From: redrum2 [REDACTED]
Sent: 18 August 2020 19:24
To: Planning <Planning@arun.gov.uk>
Subject: Application Aw/164/20/HH

For the attention of Amber Willard
In respect of 51 Westminster Drive

Dwg. no.
1921 / 03

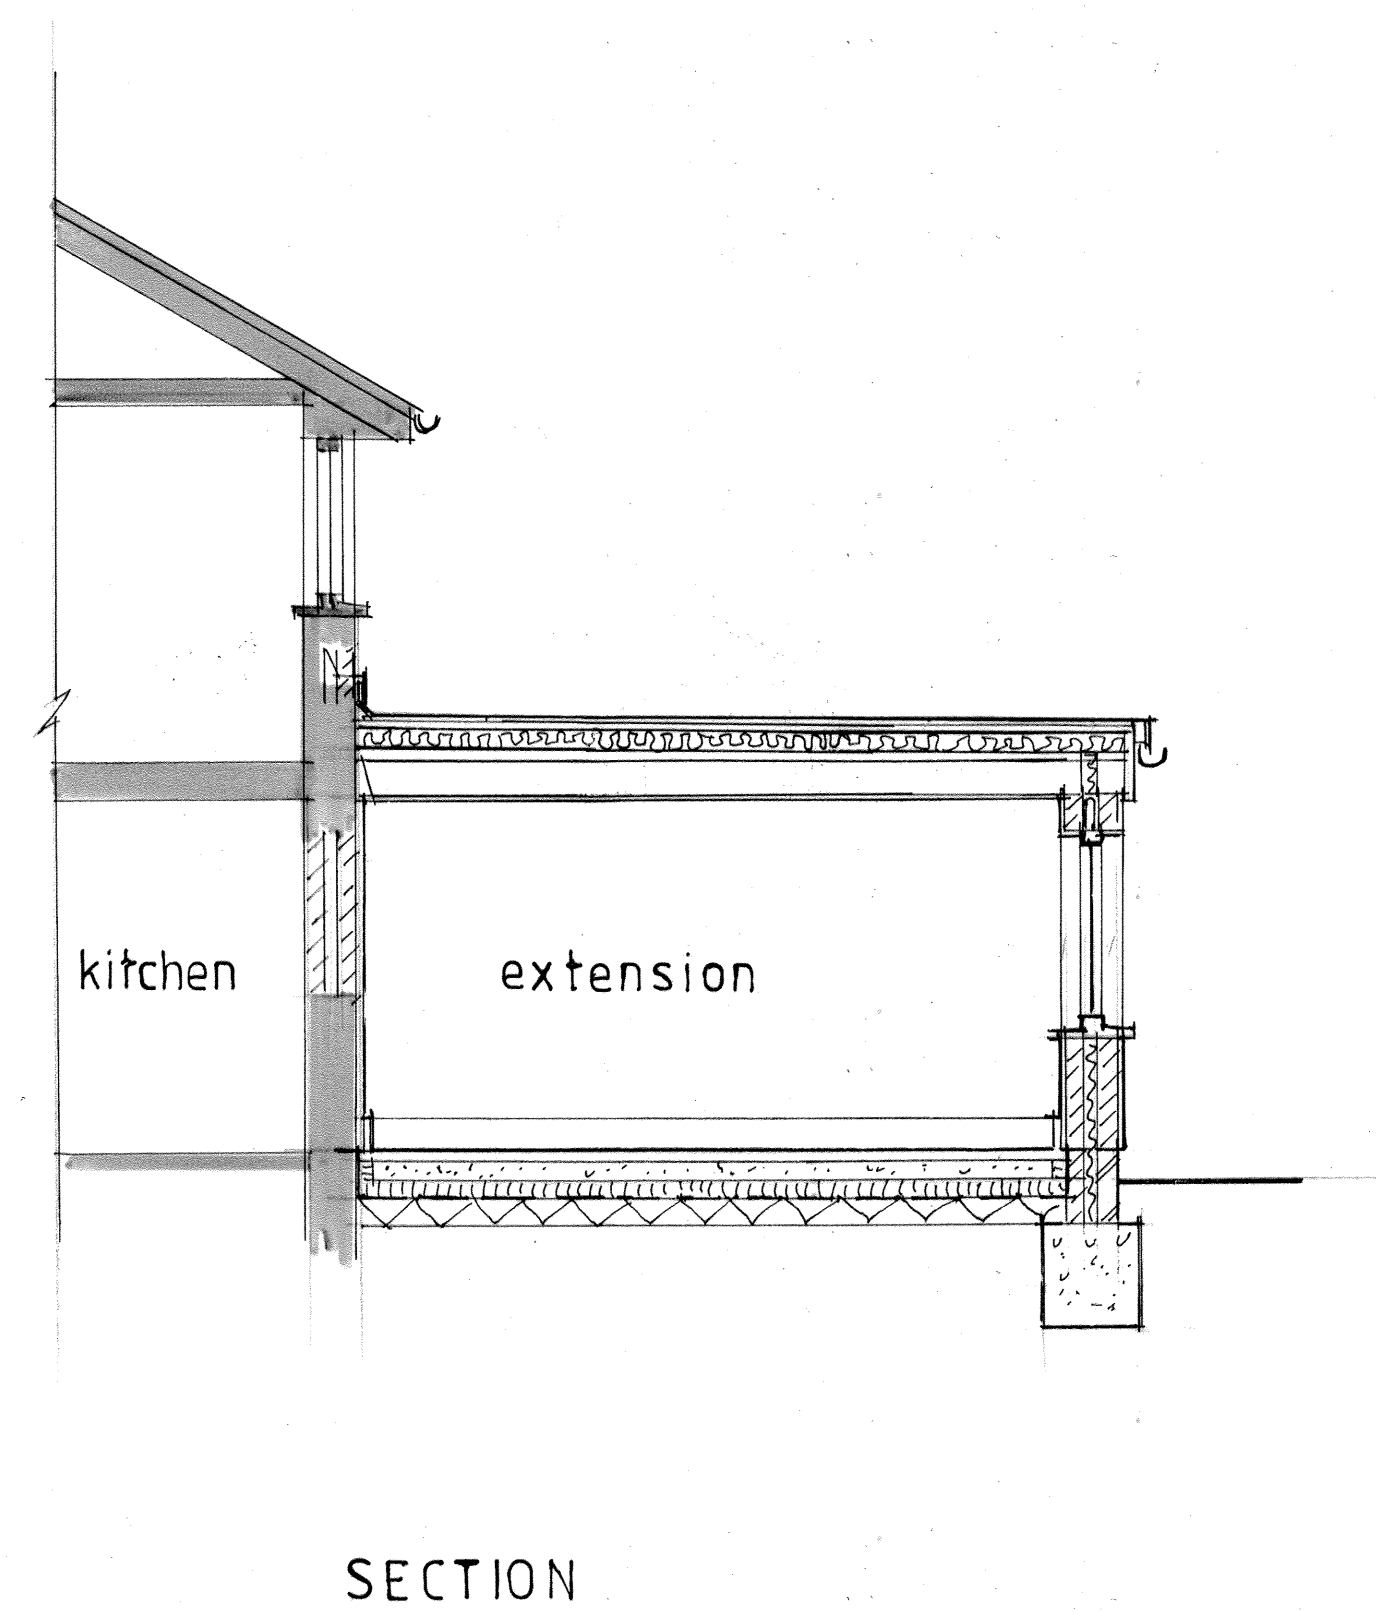
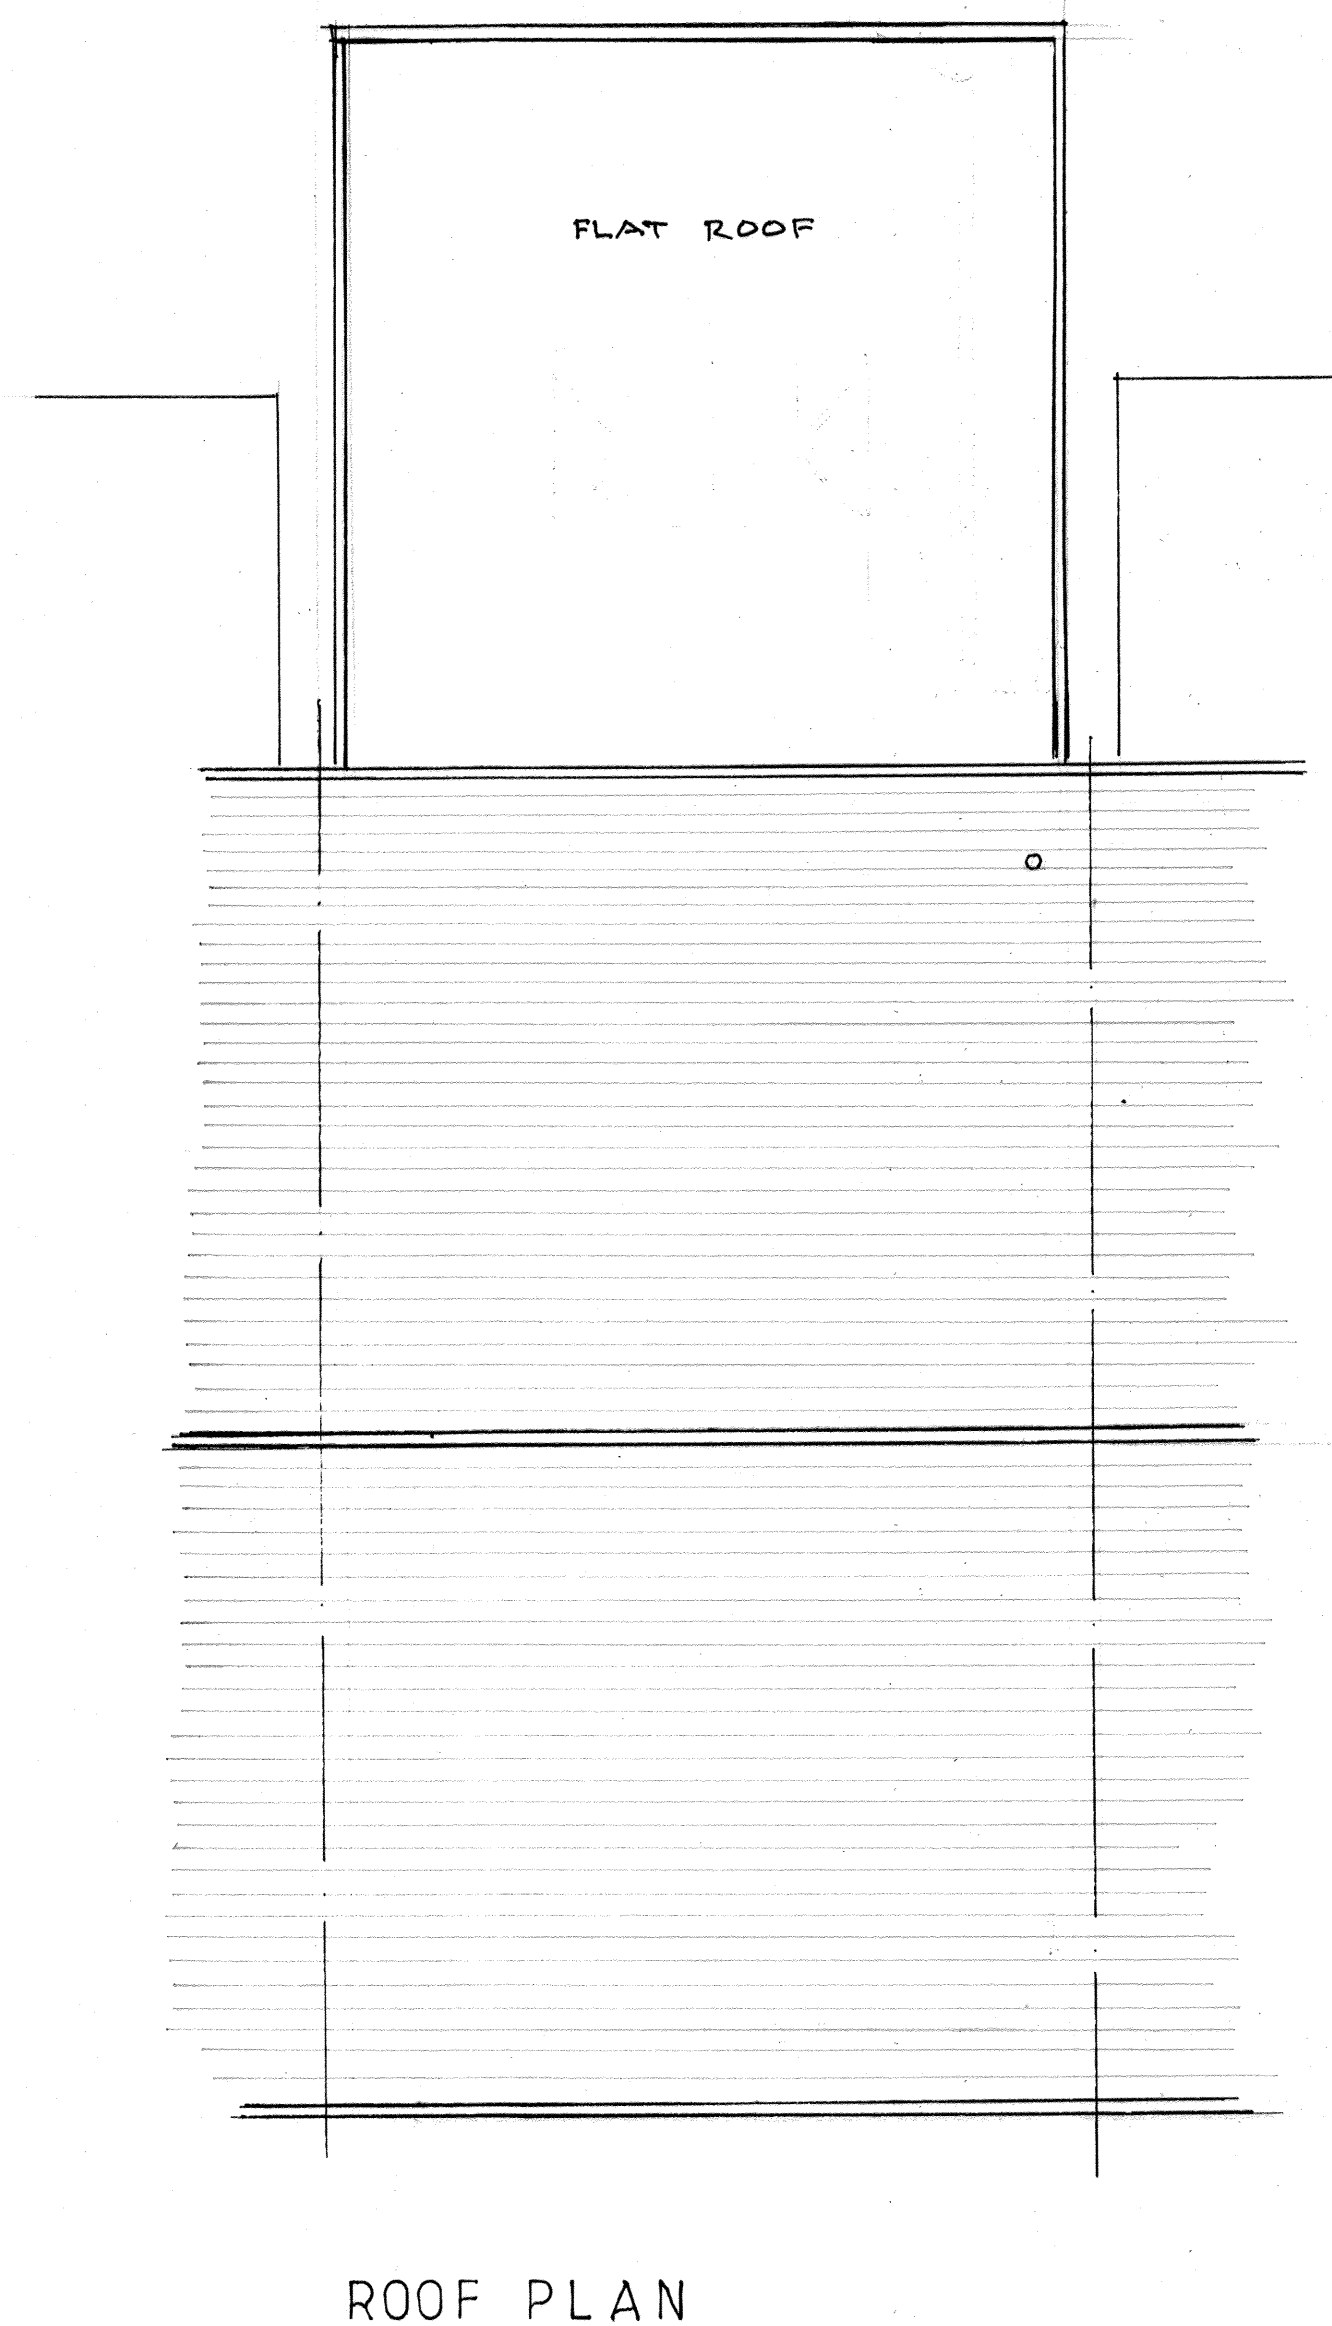
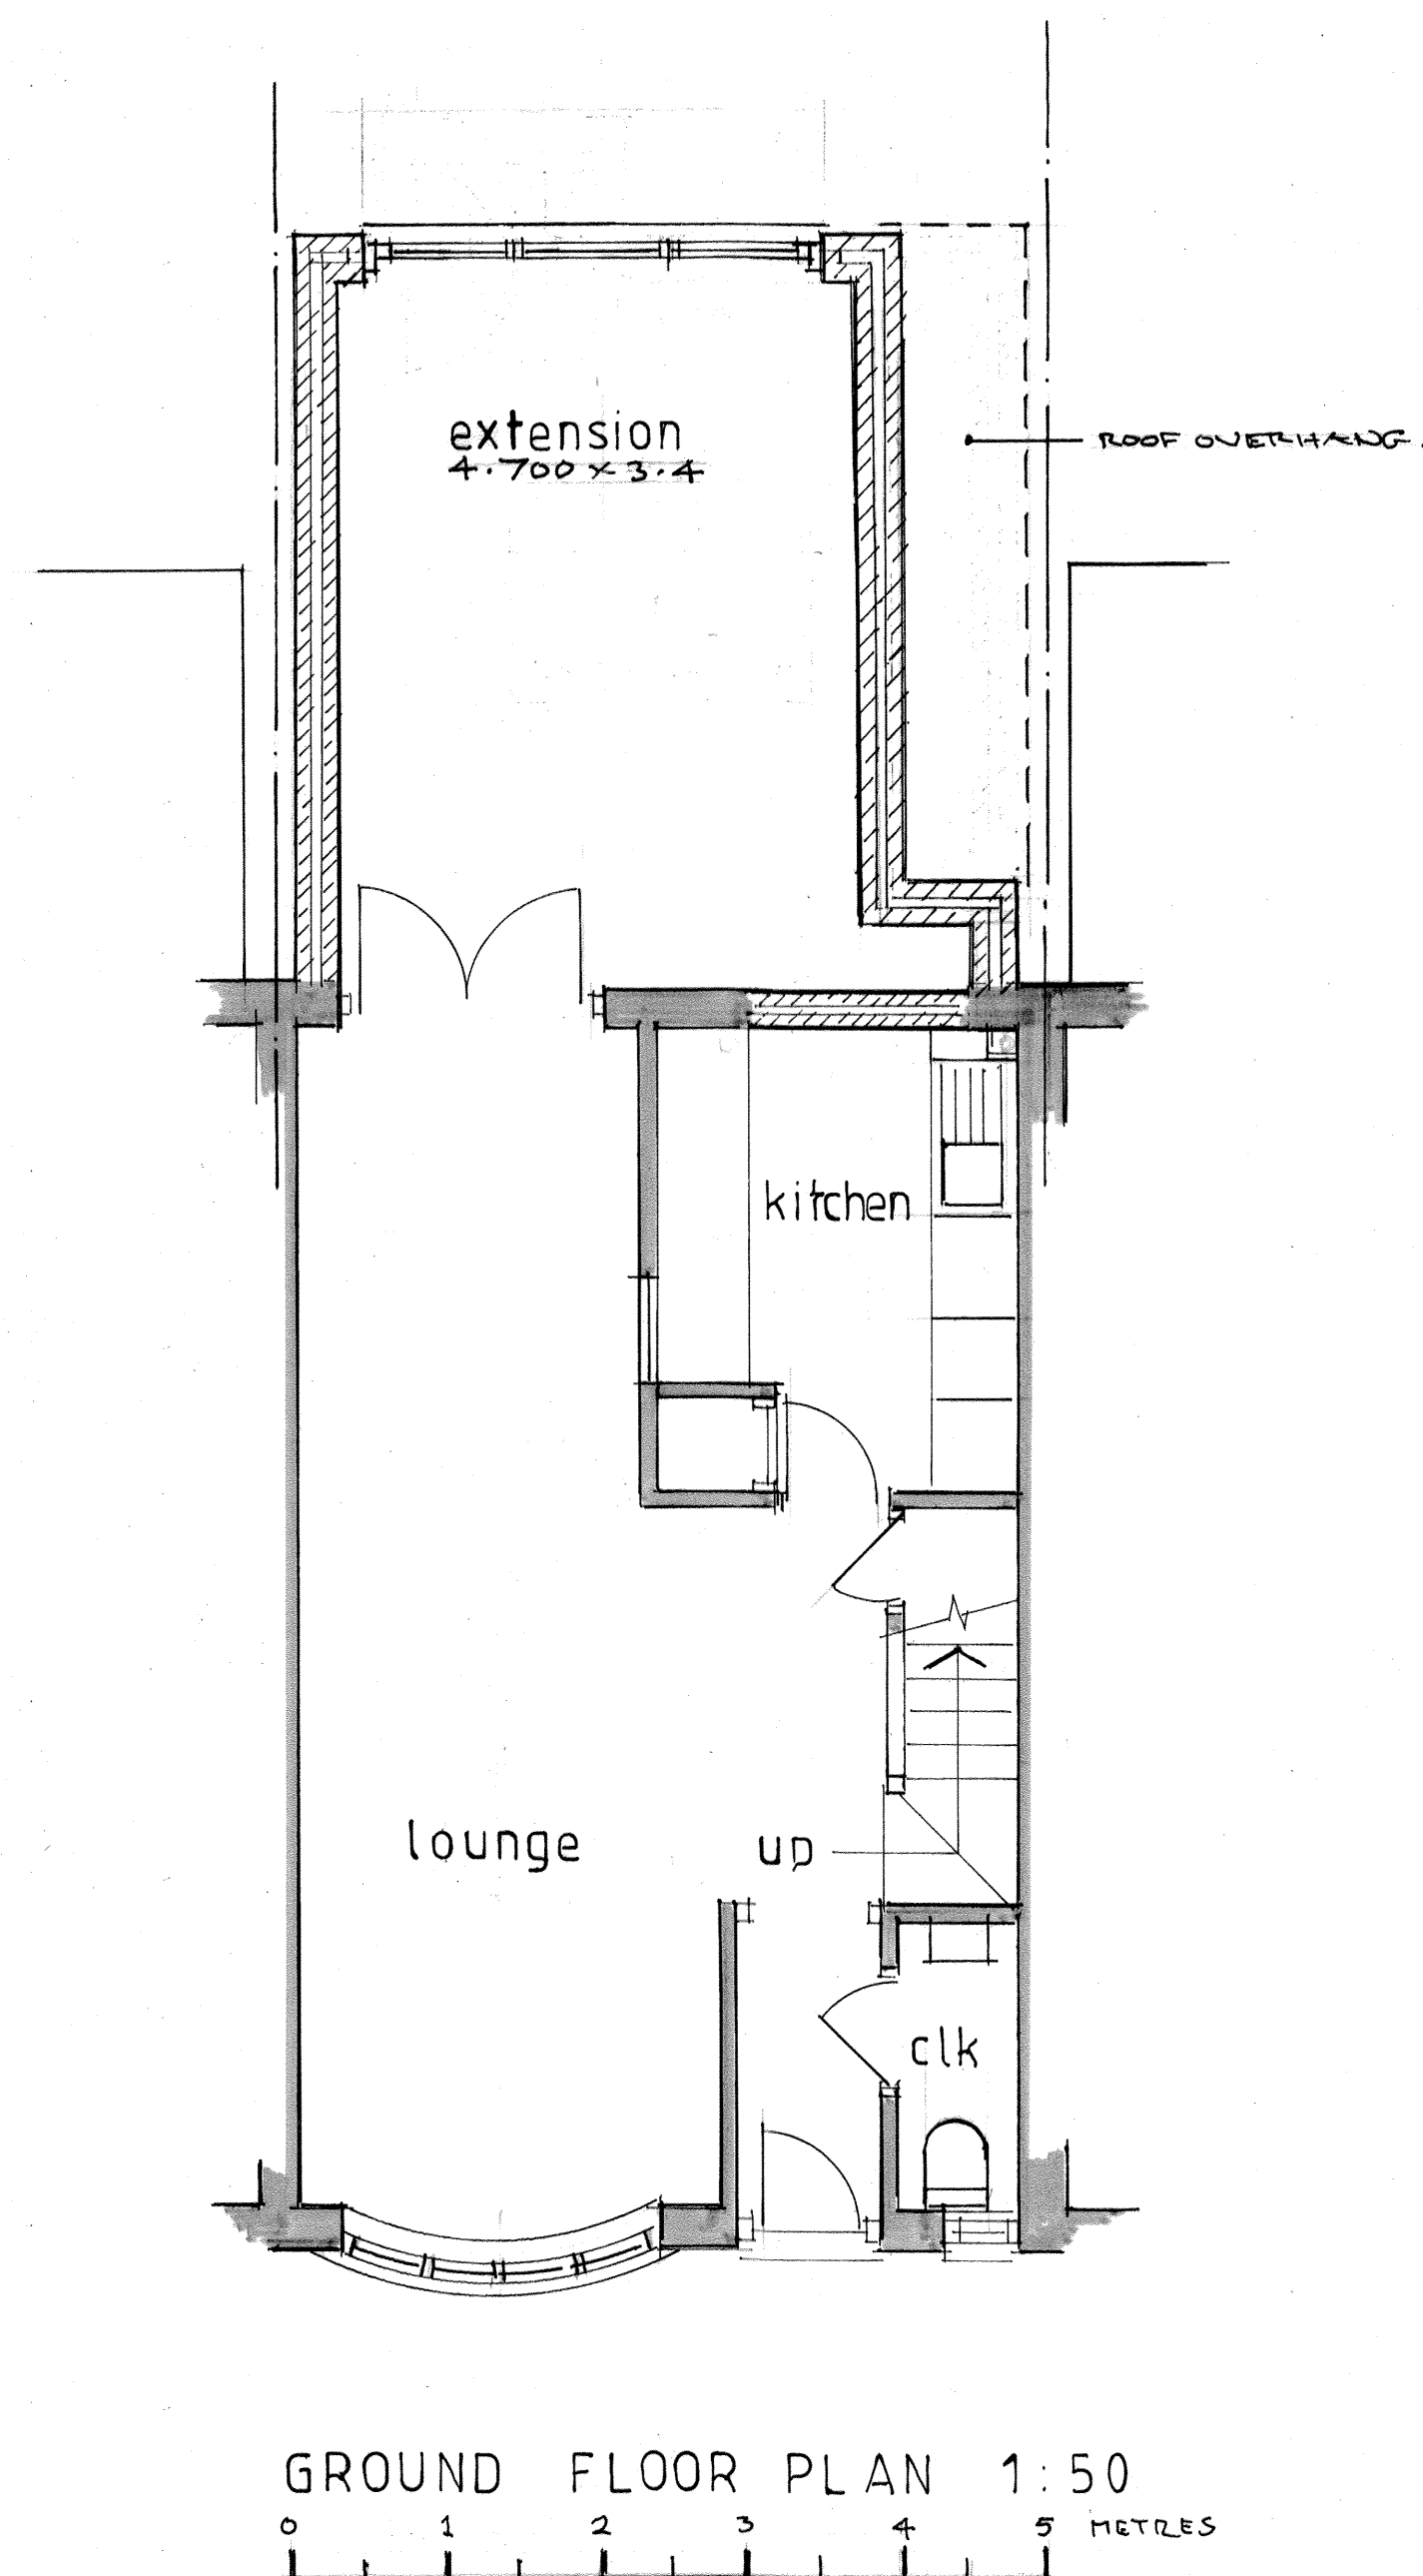
It is mainly the appearance of the Extension it is rather large and stands out with the roof being ugly, besides not matching other properties.
